From: Zac Denton
Sent: 21 September 2018 07:58
To: Planning.Responses
Subject: FW: A/99/18/L

Please upload as conservation officer response against A/99/18/L and A/98/18/HH!

From: Martyn White
Sent: 20 September 2018 16:33
To: Zac Denton
Subject: A/99/18/L

DRG. No. 37931/06

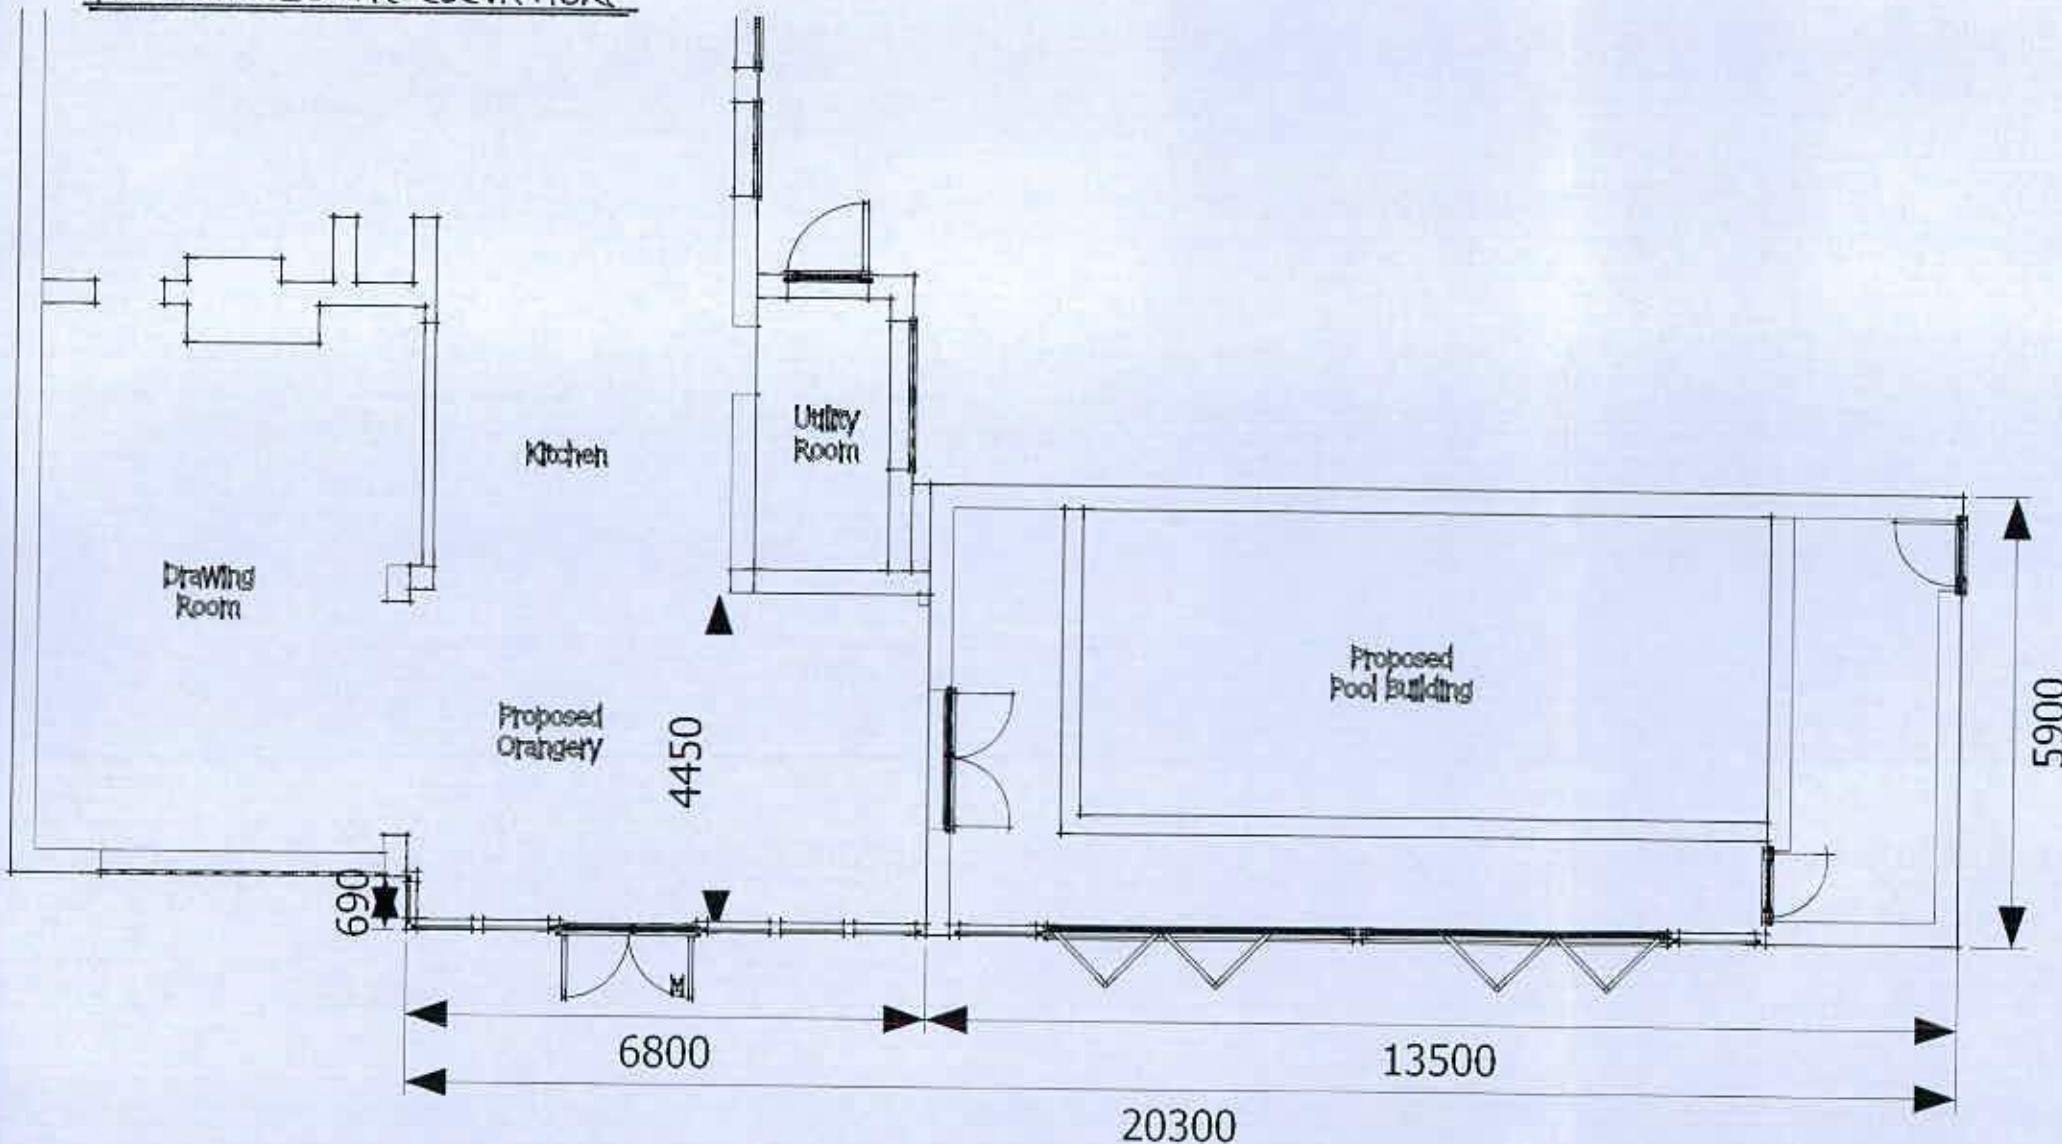
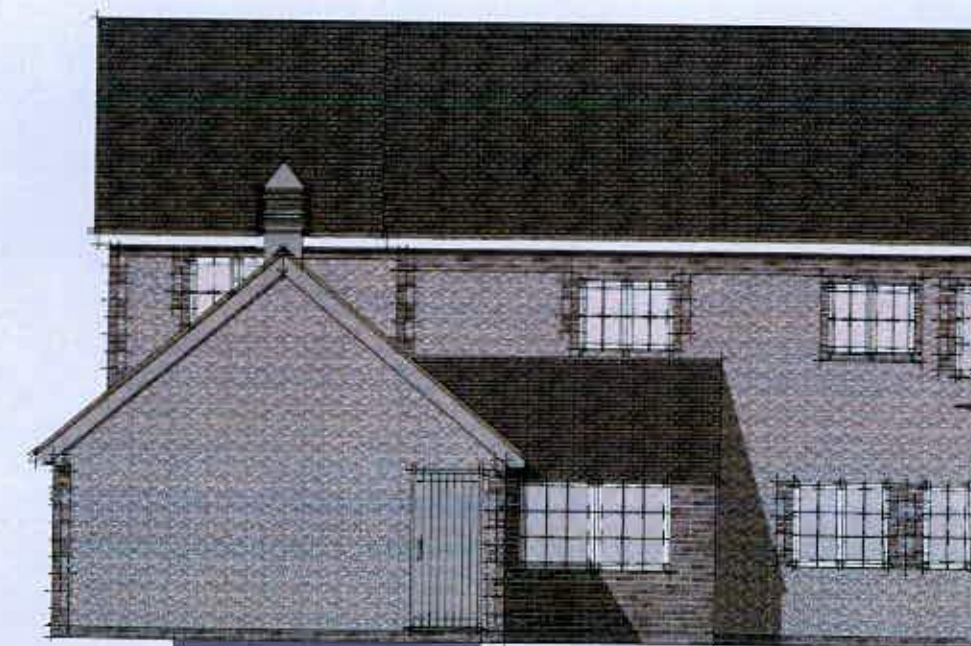
The proposal is for a replacement structure which covers a similar footprint to that to be removed. I note that the window for the existing utility will be affected by the new swimming pool structure, and care should be taken to ensure that all of the existing materials are re-used as part of the works. It is considered that the swimming pool structure is, on balance, acceptable as it reflects the structure to be removed. The ultimate success of it will be dependent upon the use of the materials and the quality of the work.

The proposed orangery is substantial, but is of a similar style to that to be removed. As a consequence, the impact upon the listed building is limited, and can be supported.

If minded to approve the applications, you may wish to condition the materials to be used.

DRG. No. 37931/04

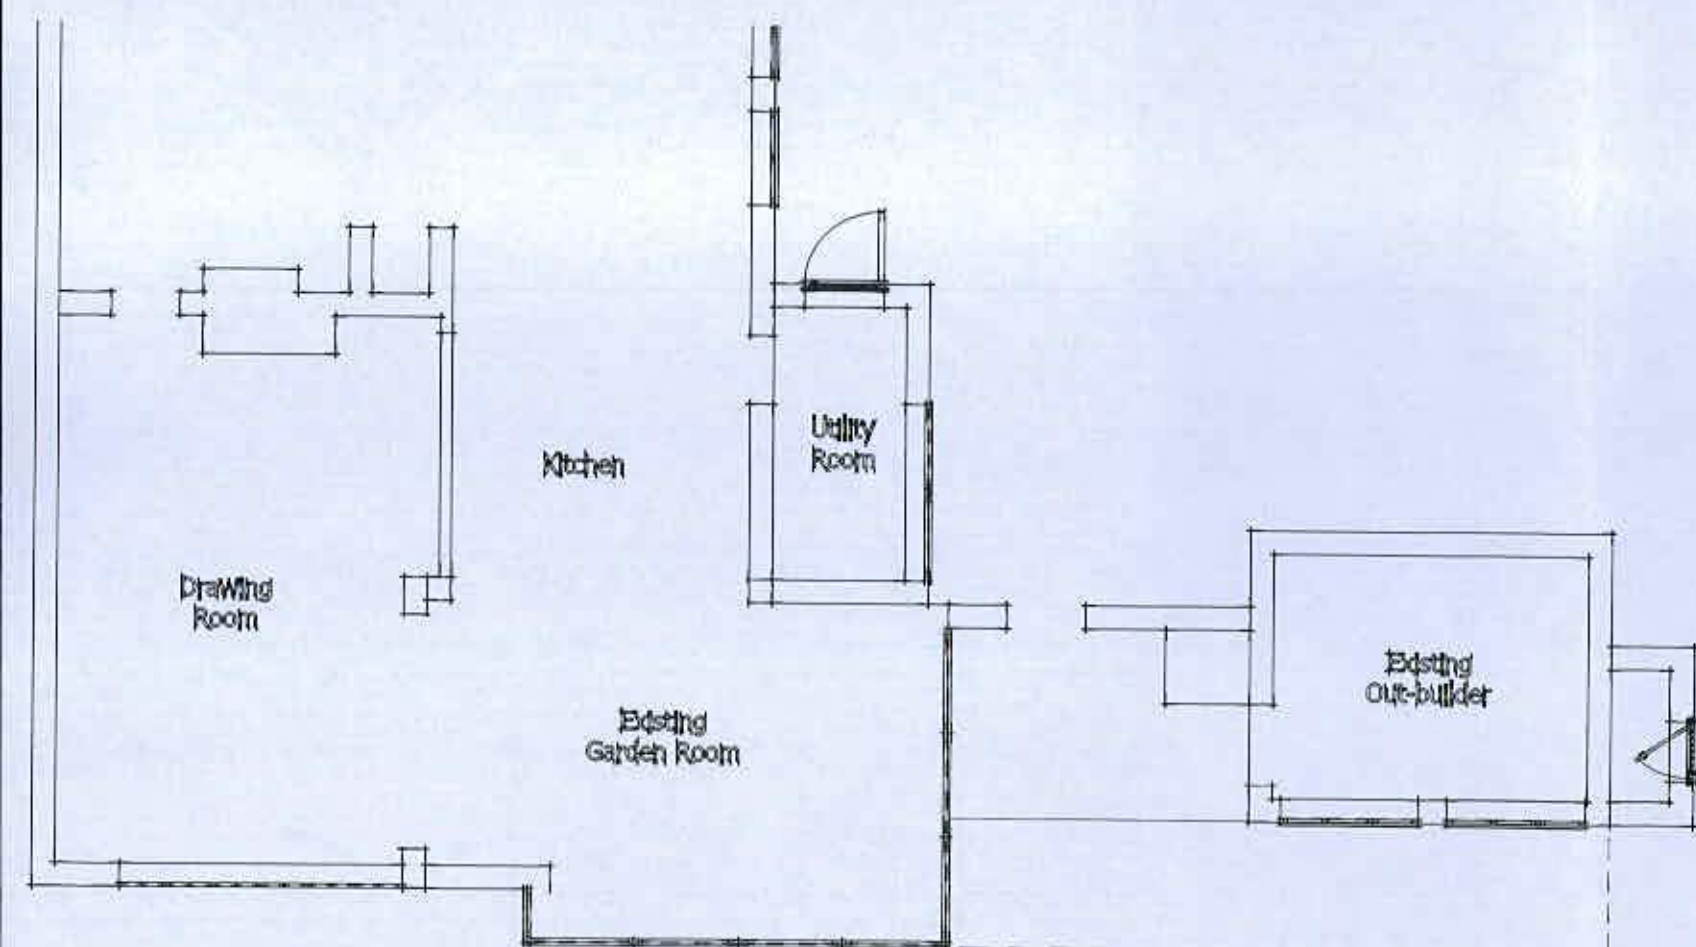
The proposal involves the loss of an existing sun room and outbuilding of no merit. The structures appear to be fairly modern in construction, and their loss is acceptable in this instance.
